**RE: PROPOSED DRAYTON SOUTH COAL PROJECT (SSD-6875)**

I refer to your e-mail dated 15 May 2015 inviting the Office of Environment and Heritage (OEH) to review the proposed Environmental Impact Statement (EIS) of the Drayton South Coal Project.

## **ATTACHMENT 1: OEH ASSESSMENT OF THE DRAYTON SOUTH COAL PROJECT**

Figure 3.6 - Saddlers Creek flood extents, 1%, 0.2% and Probable Maximum Flood

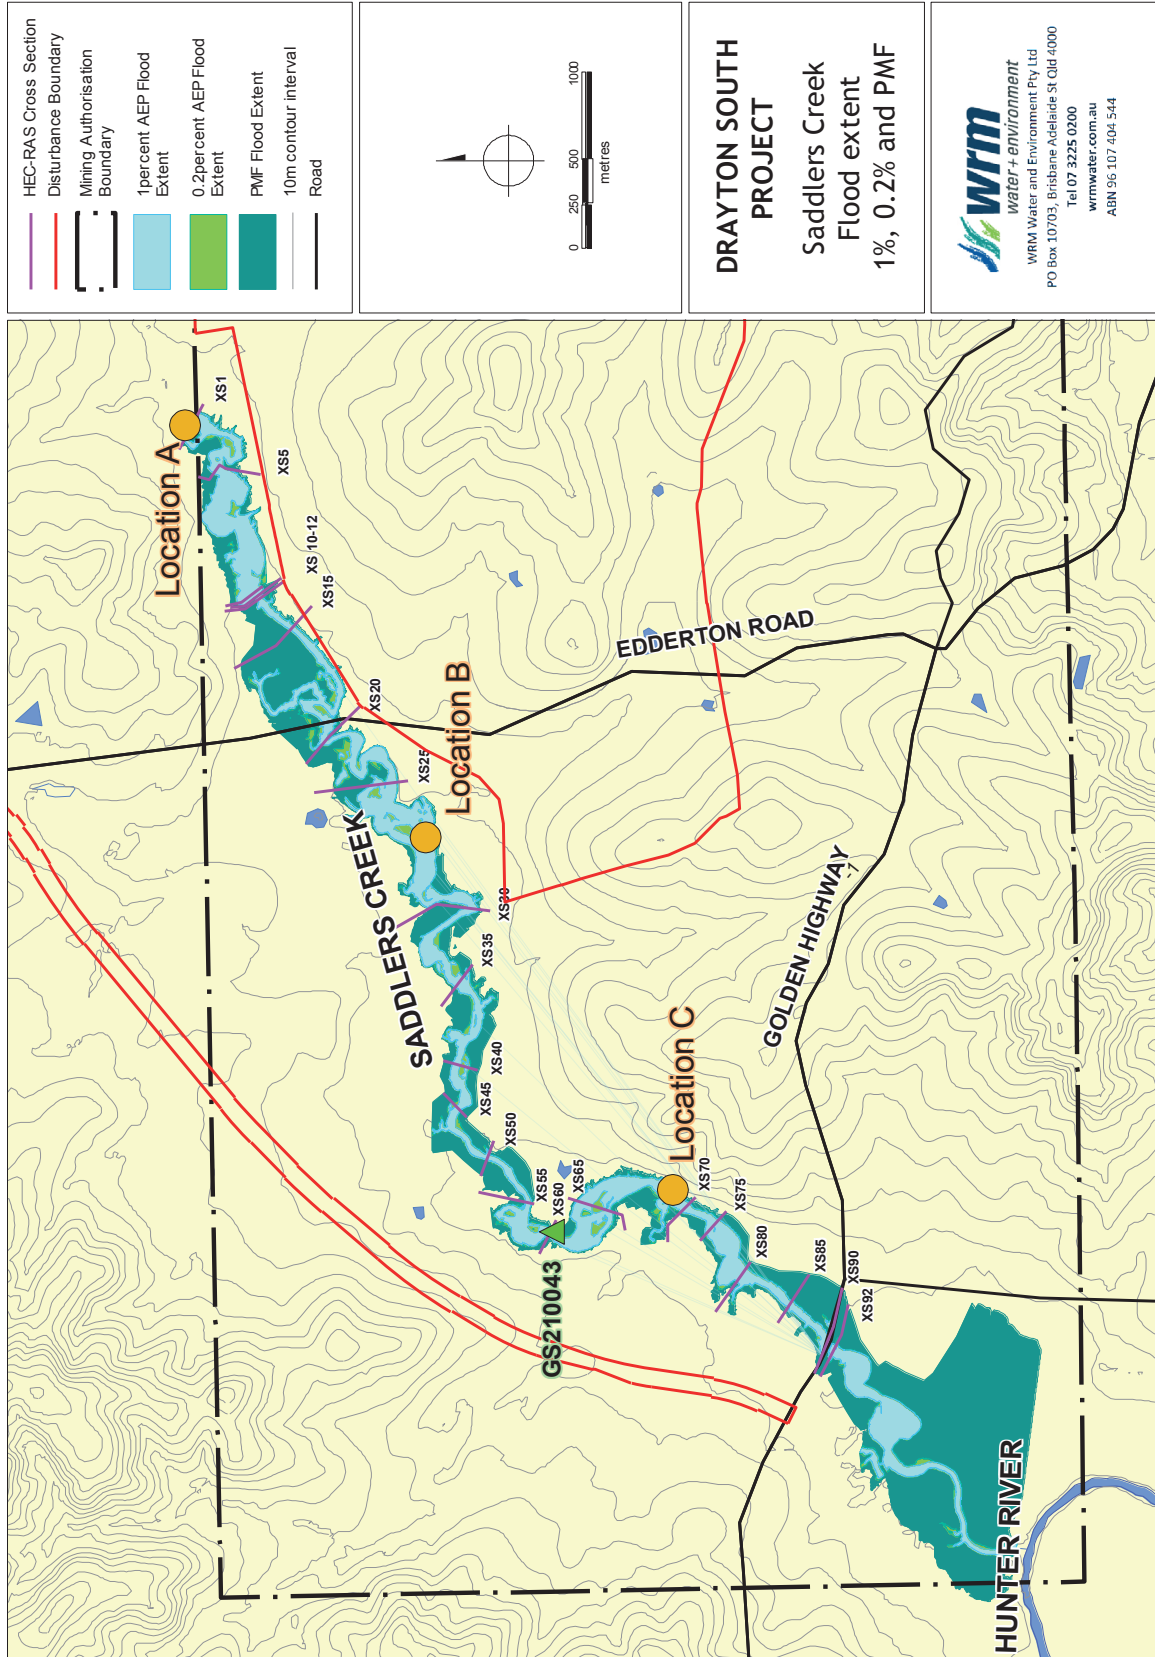
Flood assessments currently provided in the EIS are for the pre-development condition only and do not include the existing Drayton Mine or proposed Drayton South Mine. The proponents flood analysis shows the mine working to be outside of the Probable Maximum Flood (PMF) extent of both Hunter River and Saddlers Creek. It is difficult to assess the extent of the off-site flood impacts as a result of (further) modifications to creek sub-catchments included in the proposal. However, with regard to flood impacts, any proposed works must ensure that any adverse impacts are maintained within the boundaries of the land owned by the proponent, up to and including the PMF. This includes peak water levels and velocities and impacts on roads and other evacuation routes. There must be no adverse flood impacts on properties owned by others as a result of the proposed works. The proponent has proposed significant modification to Edderton Road to remove an existing floodway. The EIS states that improvements in road safety will occur as a result of realignment and raising of the road. It must be demonstrated that there is no adverse effect on flood levels or velocities results from these works on external properties. The current flood assessment does not include consideration of these proposed road works.
